**D. ALLEN HUGHES**  
**ENGINEERING, Inc.**

November 4, 2024

Reference: Evaluation of Connections of Home to Foundation Walls  
30 Corner Ln., Cameron, NC 28326  
Project No. D24mh189, Harnett County Permit No. BRES2406-0046

**DOUBLE MUD SILL FOUNDATION WALL DETAIL - D34**

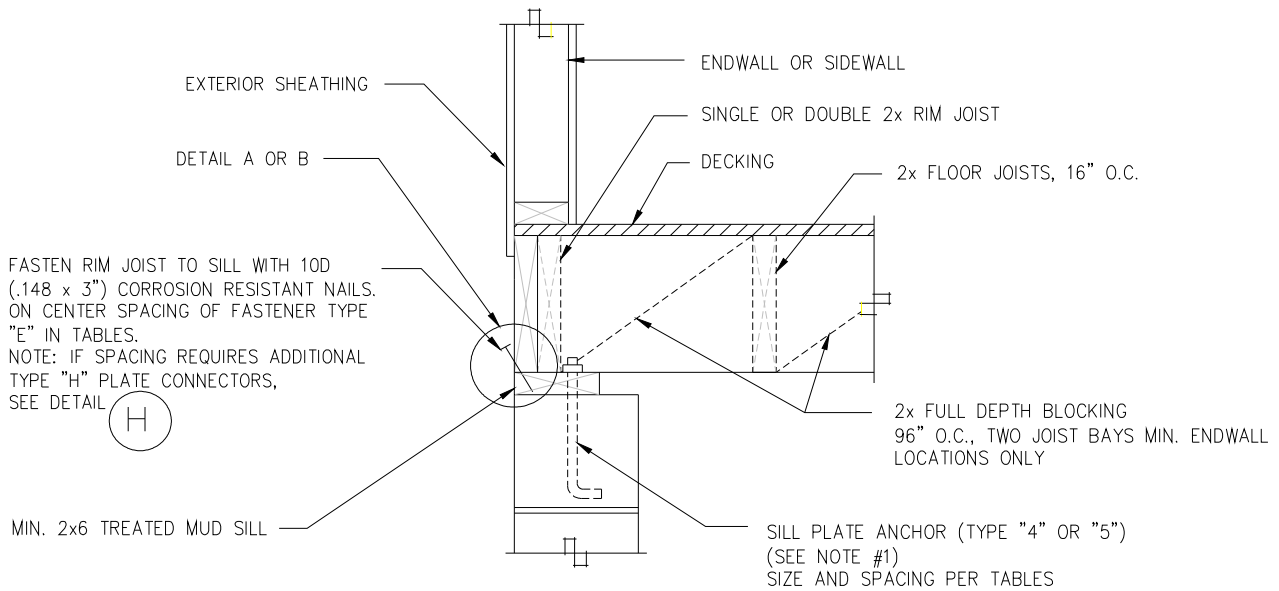
The design drawing titled "Double Mud Sill Foundation Wall Detail – D34", Page 23 of 29 dated 06/04/07 shows options of anchoring the home with nails or "H" plates. The nailing details specifies nails at a 30-degree angle downward through outer bans (at 1 in. above the bottom of the band) into the top sill plate.

Based on our evaluation, the uplift capacity of the top sill plate has been reduced by about half by countersinking the anchor holes halfway through the top sill plate. The bottom sill plate would have the full uplift capacity. Since there are more anchors than required on each side of the home, it is safe to assume that the total anchorage capacity of the top sill plate has more than half of the design uplift capacity.

At the time of our visit, the home had been attached to the upper sill plate in accordance with the nailing detail with the exception of the bump-outs which had no fastening. Our evaluation indicates that the connection between the (2) sill plates has about half the capacities of the connections between the masonry foundation wall and the bottom sill plate and the connection between the bottom of the home and the top sill plate.

It is our recommendation that the top sill plate be nailed to the bottom sill plate throughout the home in a similar manner as the nailing detail shown on Page 23 of 29 as referenced above except that the nails may be spaced at 6 in. max. along the connections.

Due to an approximate  $\frac{1}{2}$  in. overhang at the front, it is our recommendation that connections along the bump-outs of the home to the top sill plate and the top sill plate to the bottom sill plate be nailed according to the design nailed connection detail. In the case of the bump-out areas, it will be necessary to drive the nails in the upward direction. When driving upward, the nails should start at 1 in. below the joint through which the nail passes at 30 degrees from vertical. The home to top sill plate nailing should be spaced no further than 3 in. along the bump-outs. Harnett County or D. Allen Hughes Engineering should observe the modified nailed connects prior covering the connections.
